Re: Proposed N6 Galway ring road
Your Ref: 07.302848
My Ref: 15-1089

**Submission on Application to An Bord Pleanála under
S. 37 of the Planning and Development Act 2000**

Application Ref. 07.302848

Development: N6 Galway City Ring Road (N6
 GCRR)

Job No: **233985-00** | Drawing No: **Figure 15.3.06** | Issue: **I1**

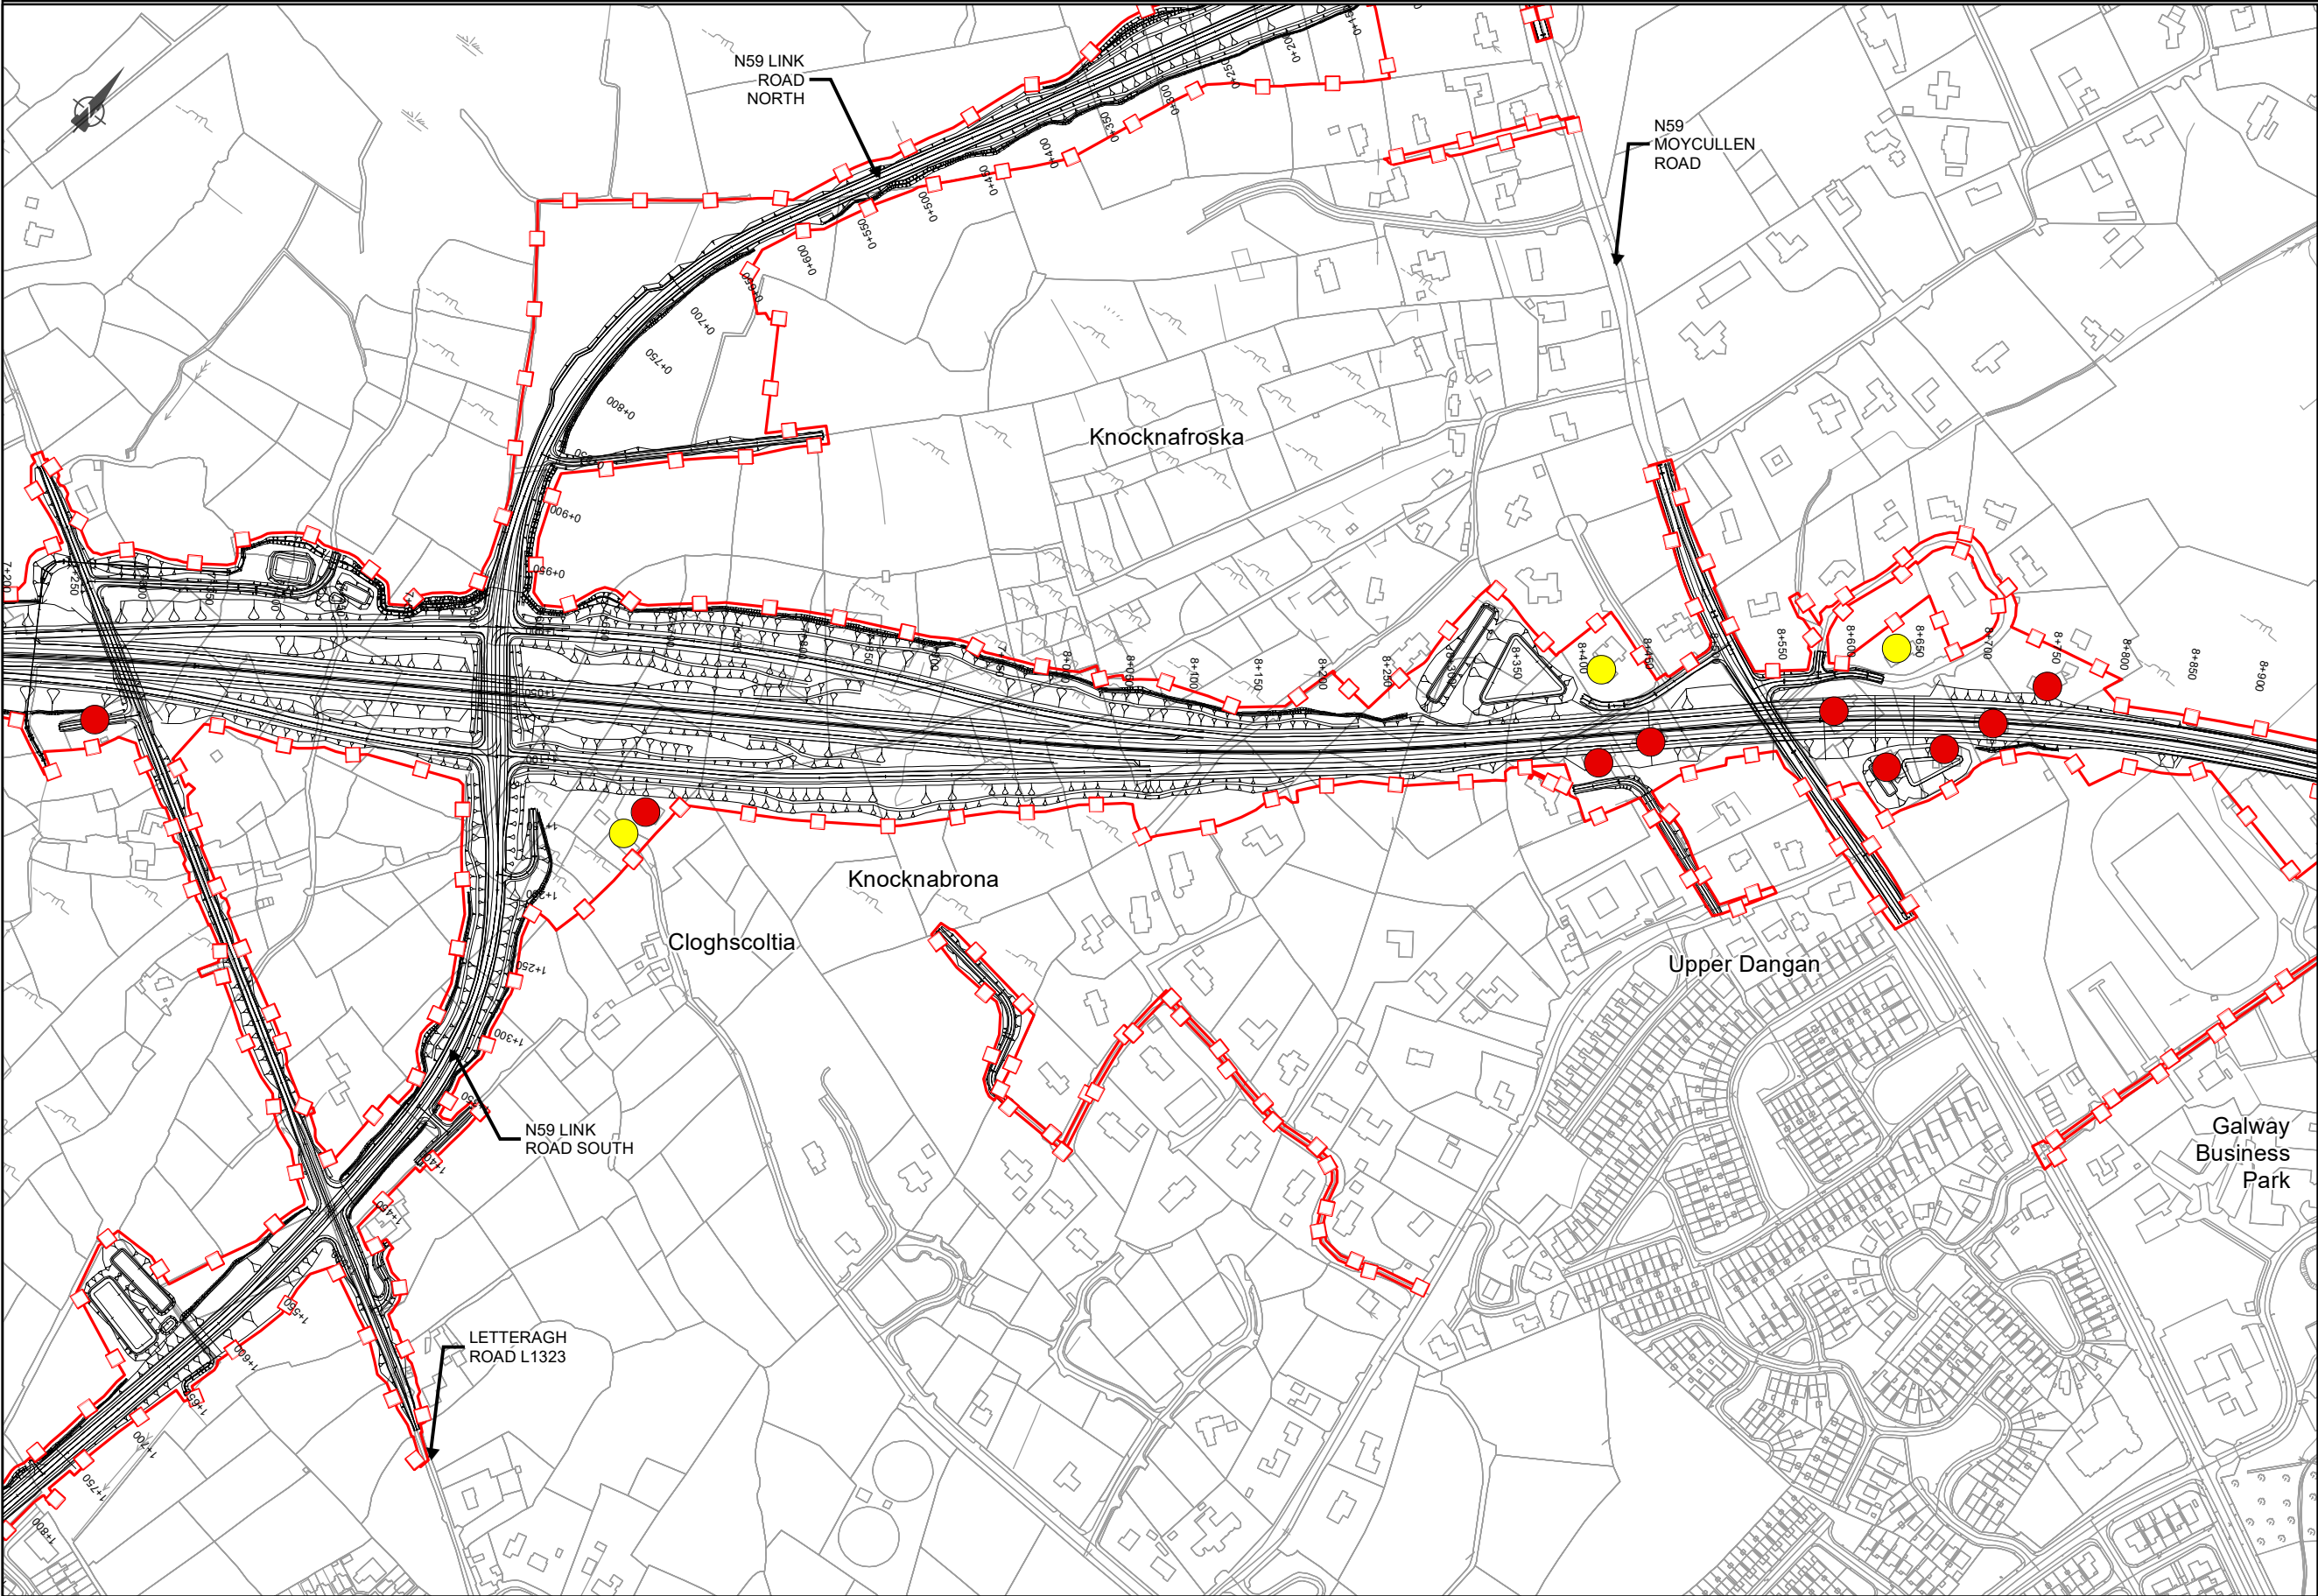
The development requires the demolition of a total of 44 houses and the acquisition of a further 10 houses (EIAR, P. 1519). This includes two houses to be acquired in Dangan and another 7 to be demolished. (Table 15.4, see also Figure 15.3.6) - five in Aughnacurra and 2 in Ard na Locha. Other sites are to be partially acquired. Elsewhere, two industrial properties and 2 commercial properties are also to be demolished.
